**From:** Bloomer, David <David.Bloomer@lancashire.gov.uk>  
**Sent:** 15 December 2016 12:17  
**To:** Stephen Kilmartin  
**Cc:** LHS Customer Service; planning  
**Subject:** FW: app3/2016/1103 Field Barn Old Langho Road

**From:** Bloomer, David  
**Sent:** 08 April 2016 13:32  
**To:** Stephen Kilmartin <[Stephen.Kilmartin@ribblevalley.gov.uk](mailto:Stephen.Kilmartin@ribblevalley.gov.uk)>  
**Cc:** LHS Customer Service <[lhscustomerservice@lancashire.gov.uk](mailto:lhscustomerservice@lancashire.gov.uk)>; 'planning' <[planning@ribblevalley.gov.uk](mailto:planning@ribblevalley.gov.uk)>  
**Subject:** app3/2016/0241 Field Barn Old Langho Road

SITE PLAN 1:200

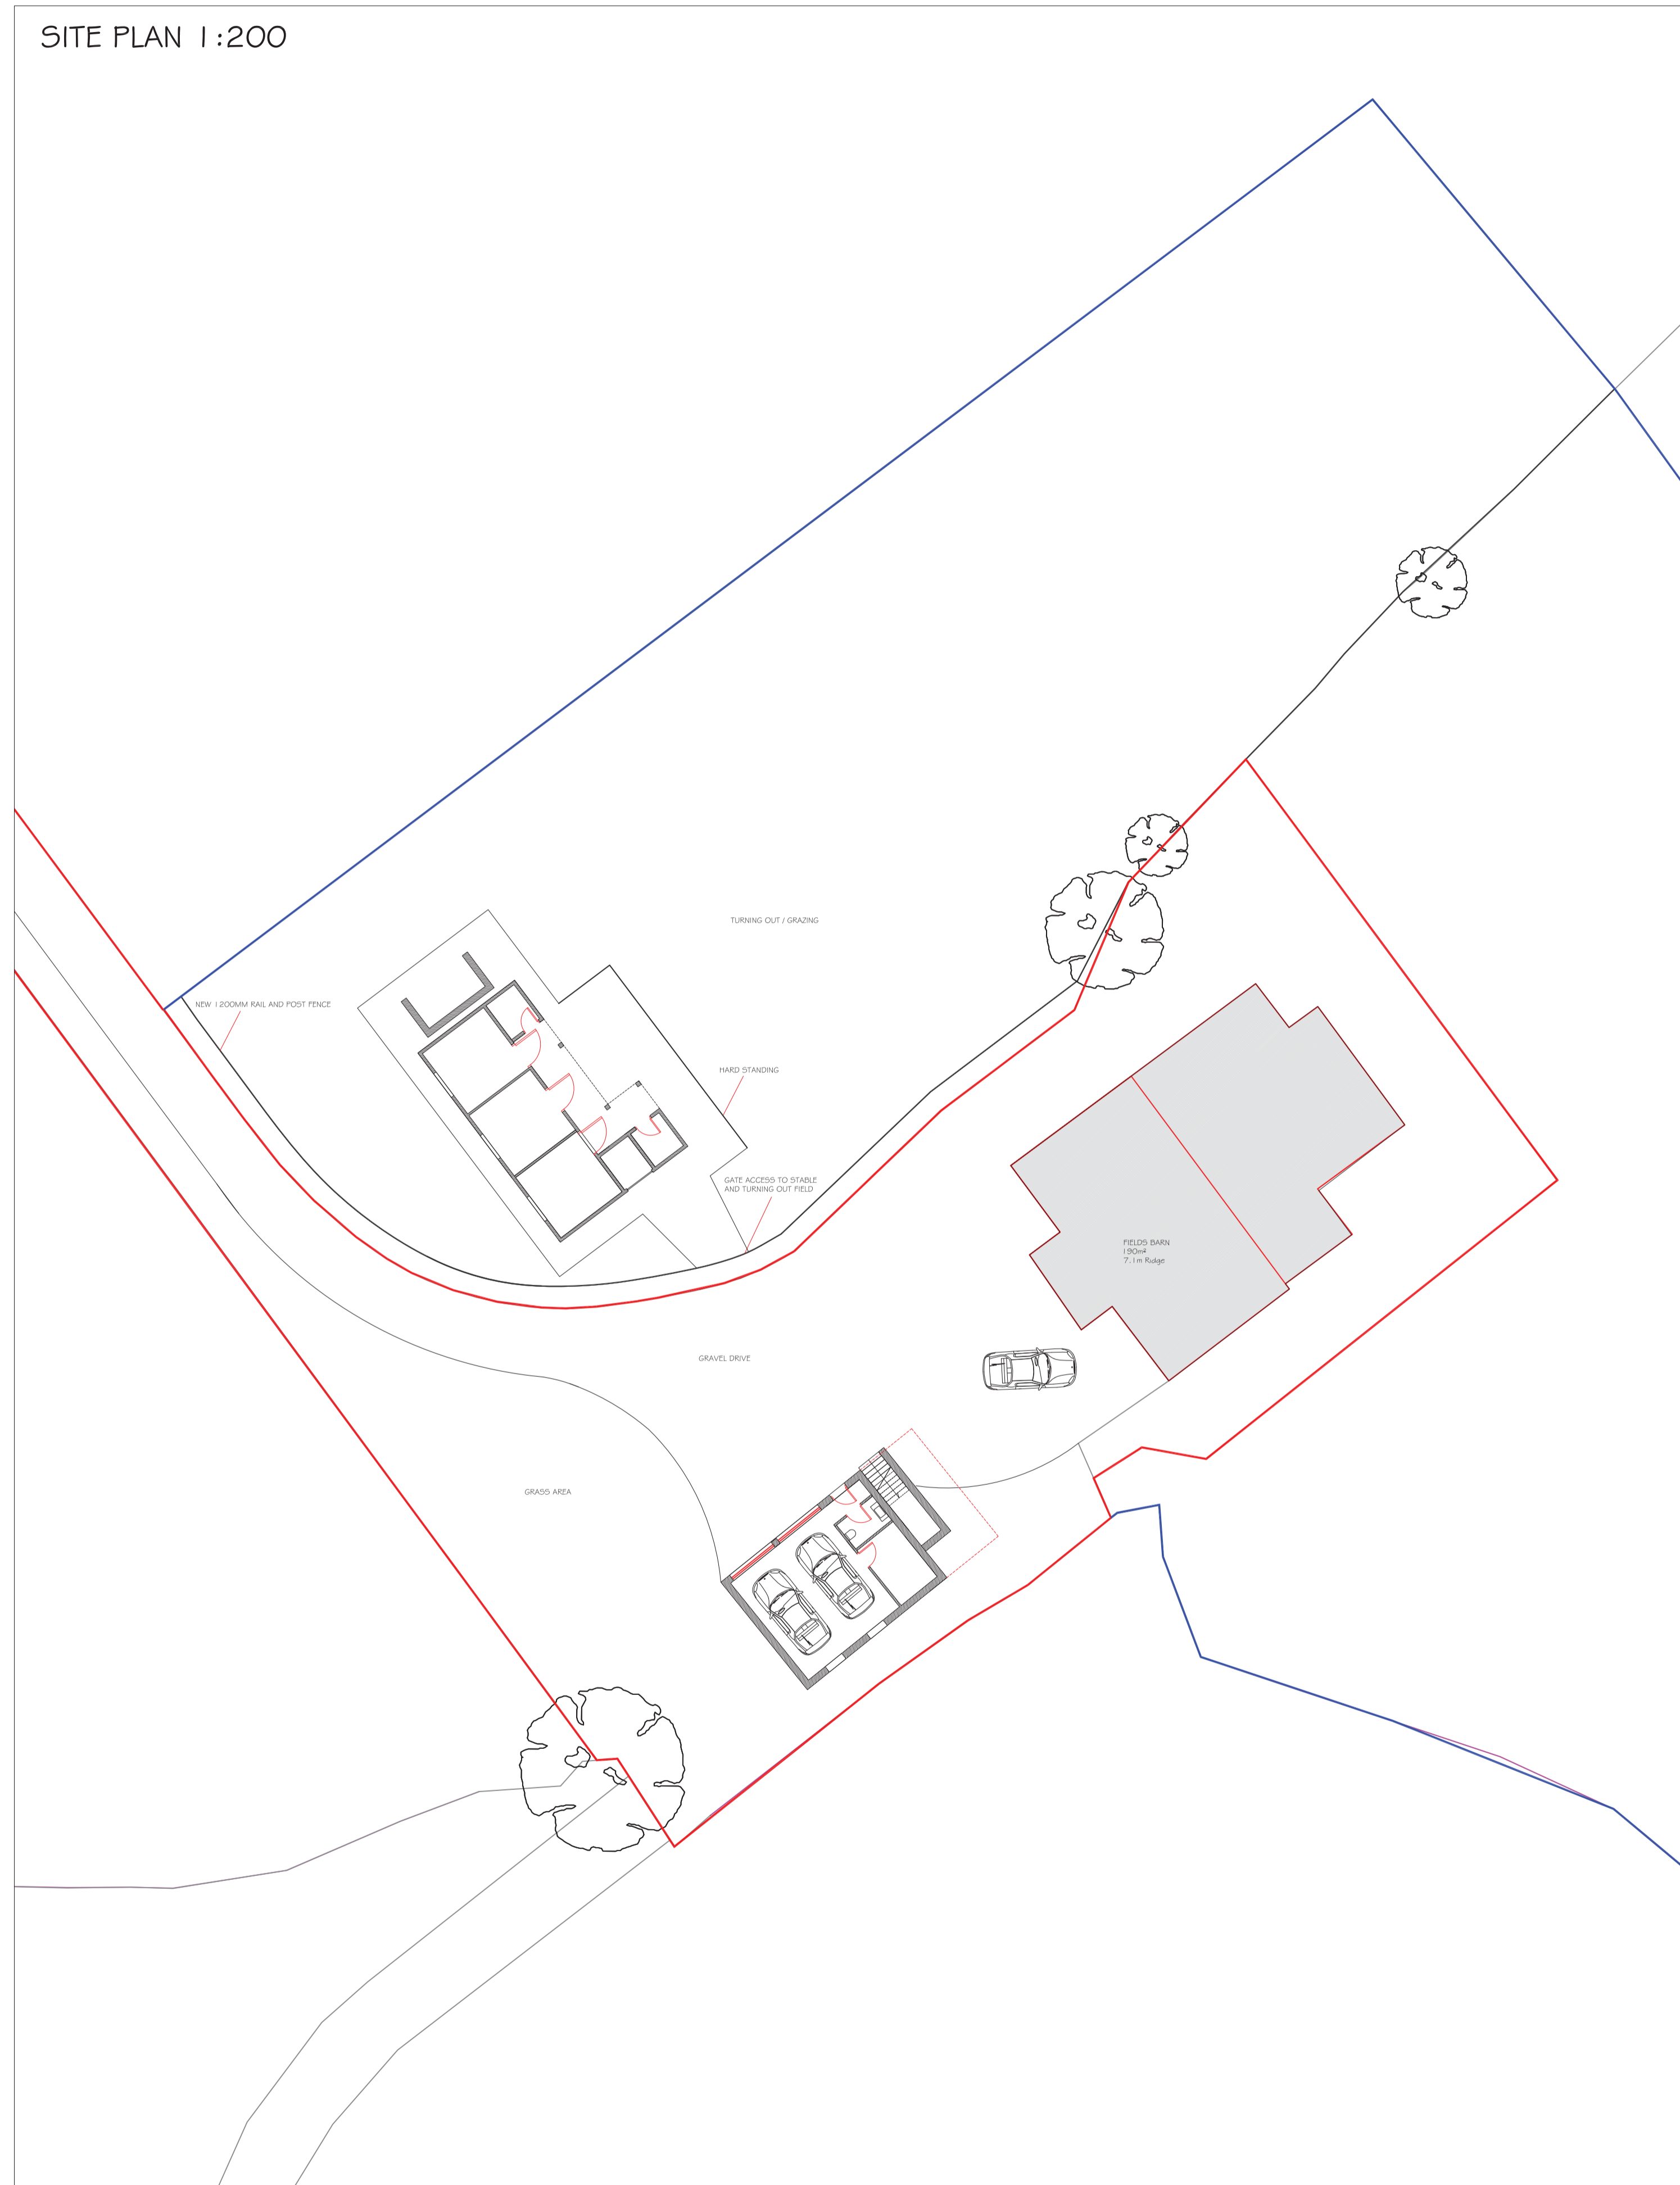
Whilst I would raise no objection to the proposal on highway grounds I have attached my response to a previous application for the site in which I noted that the access track had not been surfaced. Having visited the site recently, the access on to Old Langho Road has still not been surfaced .
